DECISION DELEGATED TO HEAD OF PLANNING

Application No:	H07-0256-22	Applicant:	Mr L Kennally
Proposal:	Details of landscaping, screening along south-western boundary, foul & surface water disposal, soakaway system, means of storage & disposal of refuse & recycling for Plots 2 & 3, ecological survey, ecological biodiversity measures to be installed and archaeology (Conditions 3, 4, 6, 7, 9, 10, 11, 12 and 13 of H07-0989-21)		
Location:	Sunray 21 Hillgate Gedney Hill		
Terminal Date:	6th January 2023

The application is to discharge conditions 3, 4, 6, 7, 9, 10, 11, 12 and 13 of H07-0989-21 (details of landscaping, screening along south-western boundary, foul & surface water disposal, soakaway system, means of storage & disposal of refuse & recycling for Plots 2 & 3, ecological survey, ecological biodiversity measures to be installed and archaeology).

Site Plan

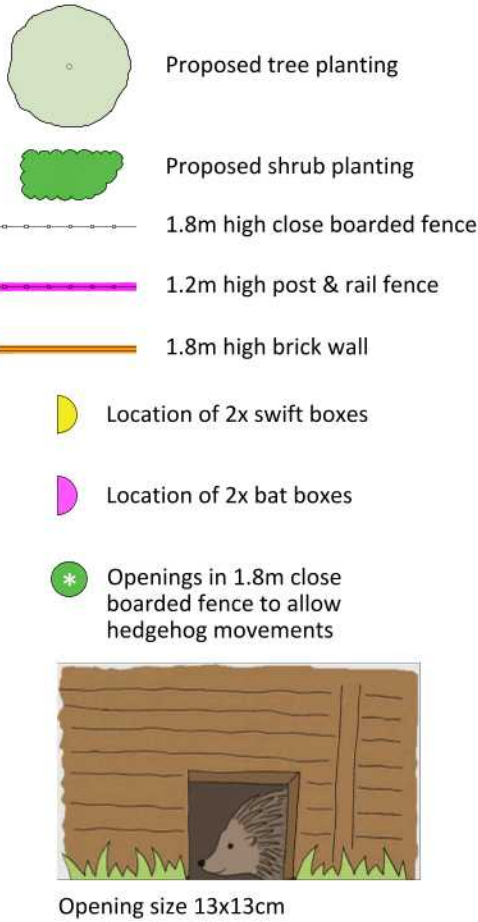
Condition 3 (details of landscaping) - The scheme includes tree planting along the site's frontage, plus hedge planting. It is considered acceptable on balance.

Condition 4 (details of screening along south-western boundary) - The existing 1.8-2 metre fence along the south-western boundary will be retained, which is considered satisfactory given that finished floor levels will only be set at 300mm in accordance with condition 5.

Condition 9 (means of storage & disposal of refuse & recycling for Plots 2 & 3) - A refuse collection point has been provided at the site's entrance for plots 2 and 3.

Condition 11 (ecological biodiversity measures) - Swift boxes would be installed on the dwellings on plots 1 and 2 and bat boxes on plot 3.

Treatment Plant & Soakaway Proposal

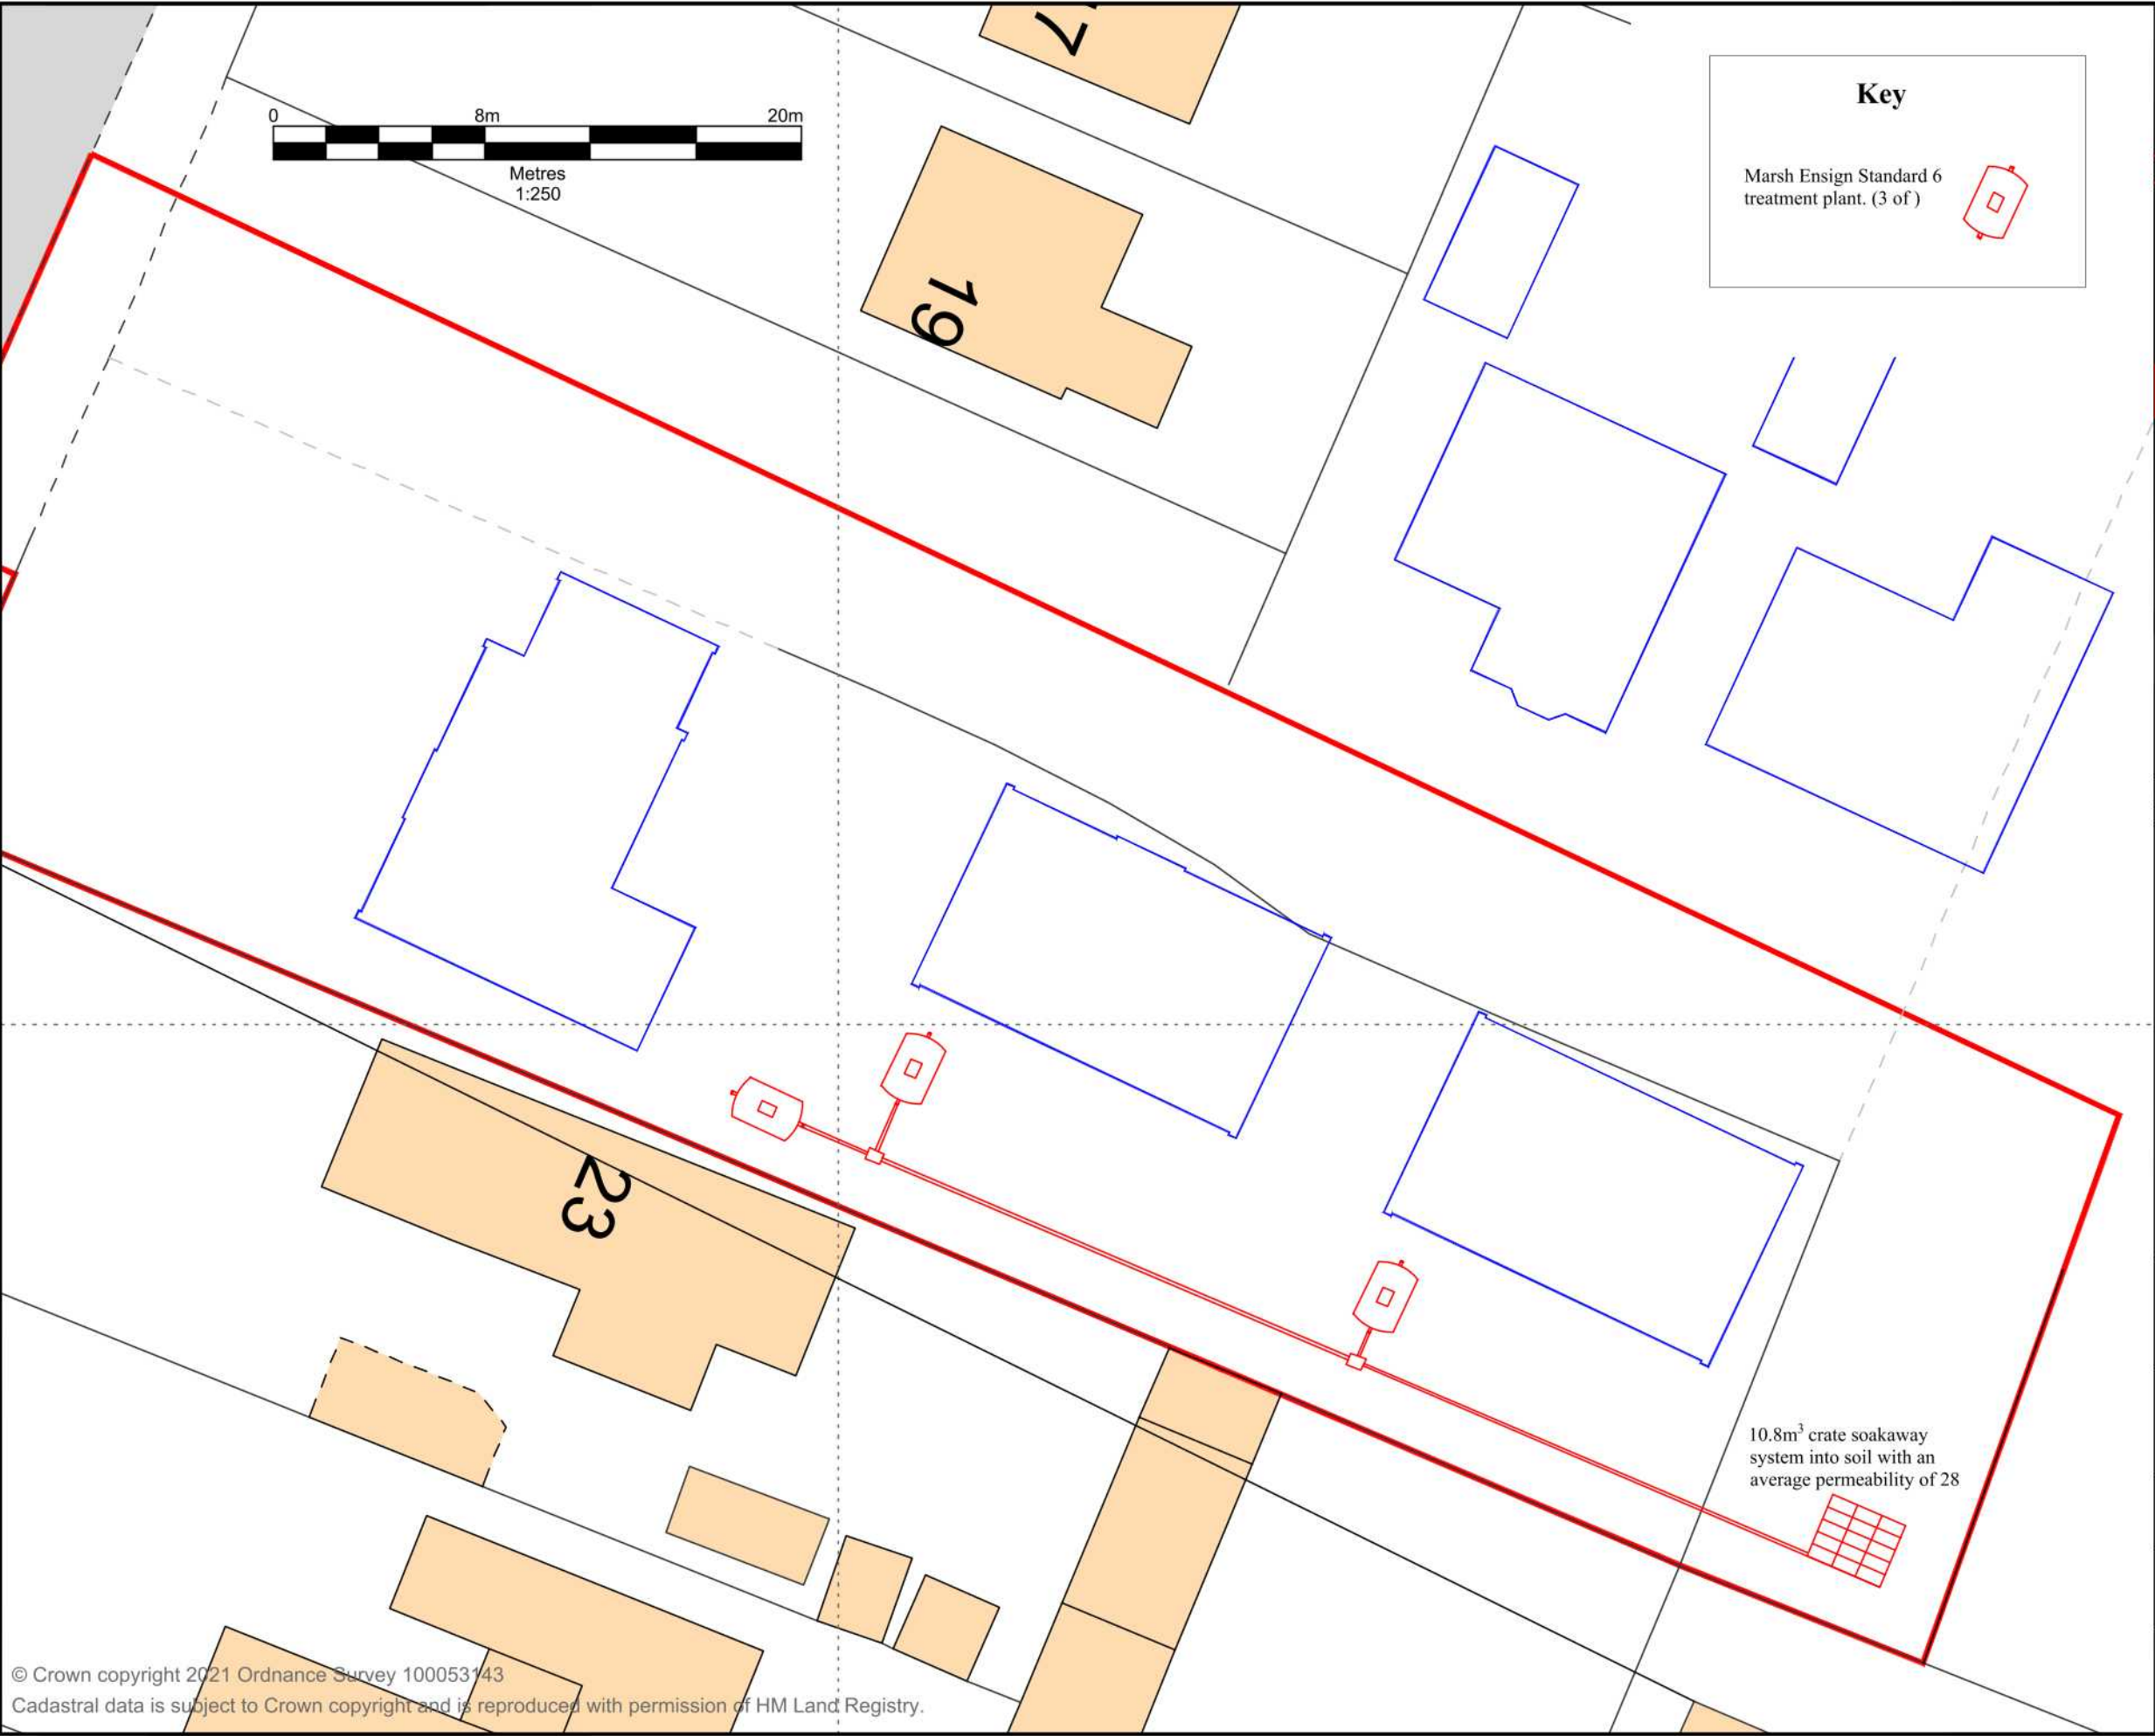
Recommend that the percolation trial pit is filled for three times repeatedly in line with BRE Digest 365. If following further infiltration testing a strategy wholly reliant on infiltration does not prove viable and a surface water discharge is proposed to a watercourse, then the proposed development will require land drainage consent in line with the Board's byelaws (specifically byelaw 3).

Condition 6 (foul & surface water disposal) - Foul water would be disposed of to individual package treatment plants and surface water to a large crate soakaway at the rear. This arrangement is considered acceptable in principle.

Condition 7 (soakaway system) - Details of percolation tests and soakaways have been submitted and are considered acceptable by Building Control.
